INTRODUCTION

This matter comes before you with one primary component: (1) a conditional use permit application for authorization of a 10-acre “campground” to include 30+ cabins, one 3000 sqft Lodge, and a 3000 sqft Maintenance Building within within the Rural Recreation (R-R) zoning district.

The Outpost project proposal converts multiple prime rural residential parcels to a commercial campground. The proposal is visually and esthetically inconsistent with the adjoining properties; dominates over the natural landscape and neighboring residential parcels; introduces adverse impacts to neighboring residential parcels; and is inconsistent with rural recreation residential development. The decision-making process balances a commercial proposal within multiple rural residential communities against a commitment to preserving and promoting rural recreation residential development associated with the area. And significantly, the project will have a direct impact on the adjacent properties.

**CONCEPTUAL SITE PLAN
MULTIPLE PARCELS**

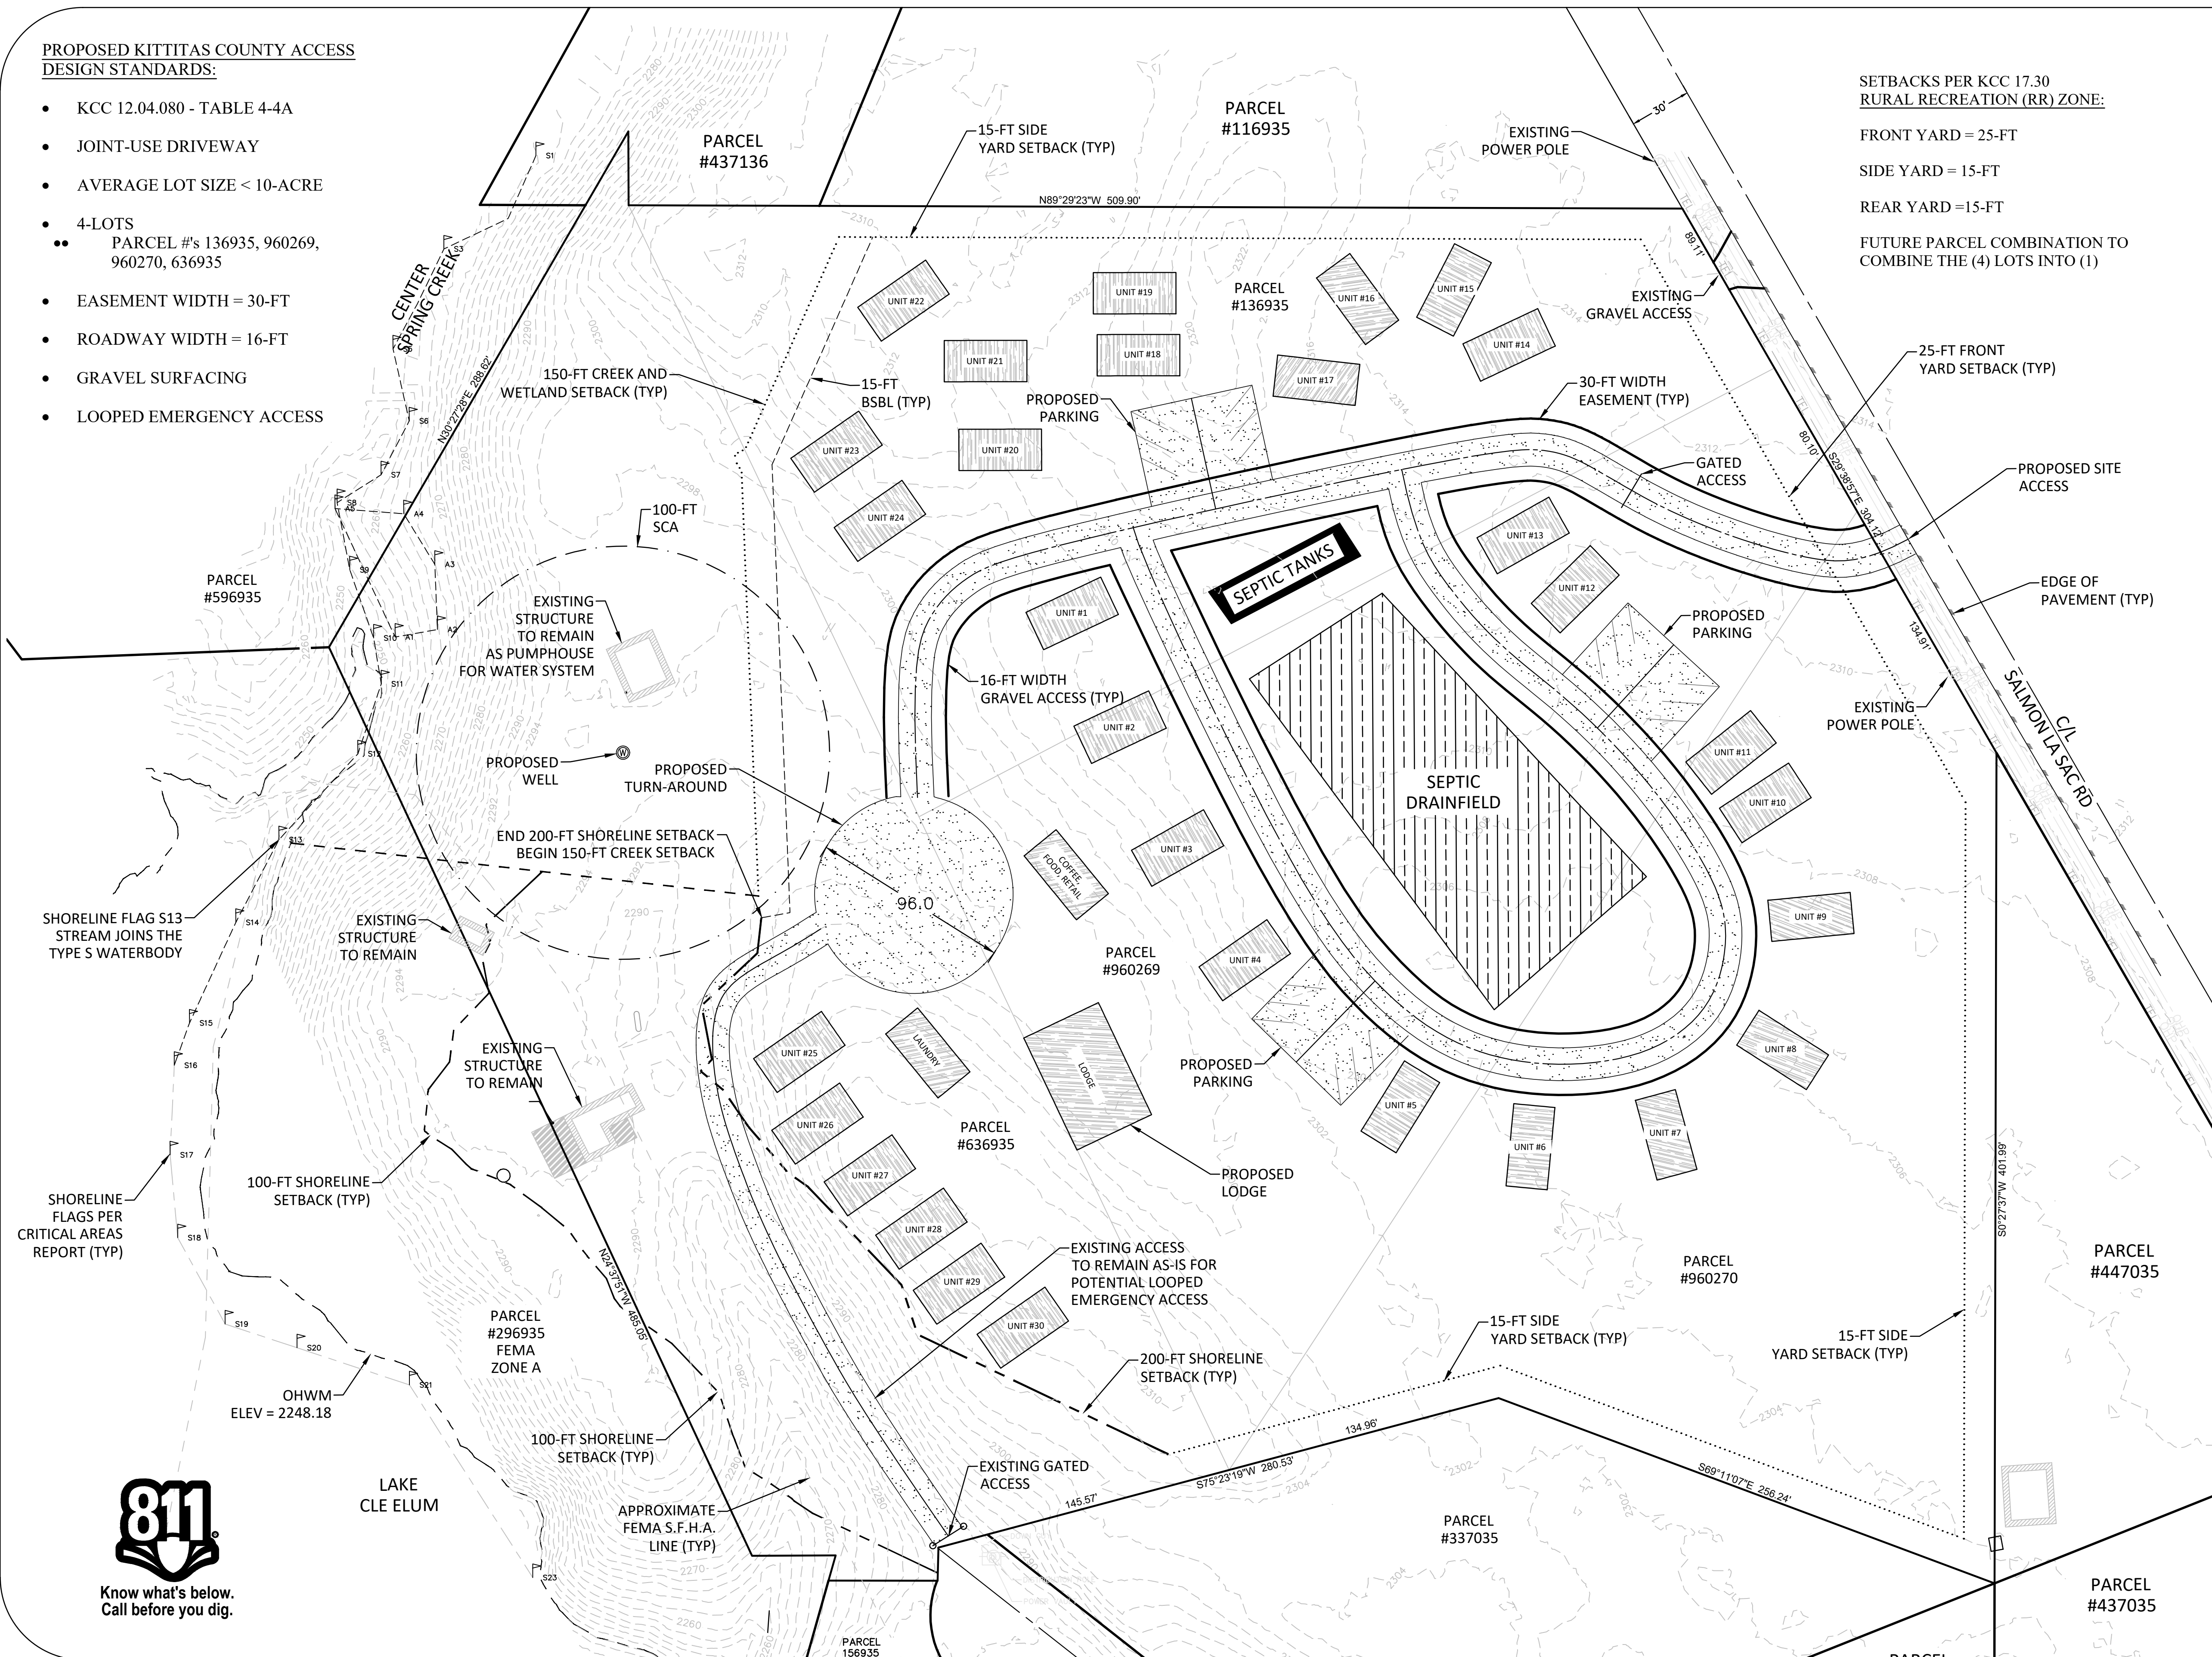
This project dominates over the natural landscape and vegetation, in fact, the vegetation will be most cleared. The square footage of the project area covers nearly all the land in the project zone and is unlike any other residential property in the area.

This project in no way fosters rural lifestyles and the proposed use is detrimental to the surrounding parcels by creating a sprawling high-density area of cabins capable of hosting over 120 adults, each bringing with them dirt bikes, side by sides, snowmobiles, etc. located in between and amongst residential homes. The noise in such a condensed area alone should be enough to prevent this sprawling high-density development from further construction. Also, no additional local jobs are created by this project.

This project does not reduce the inappropriate conversion of undeveloped land into sprawling, low-density development. It converts the area into a massive campground with a 3000 sqft meeting hall.

The natural surface flows evident in the topographical maps and surveys will be altered, but as yet we are not told how. This project will have roadways, large areas for parking, and 32+ structures that assuredly change the natural surface flow.
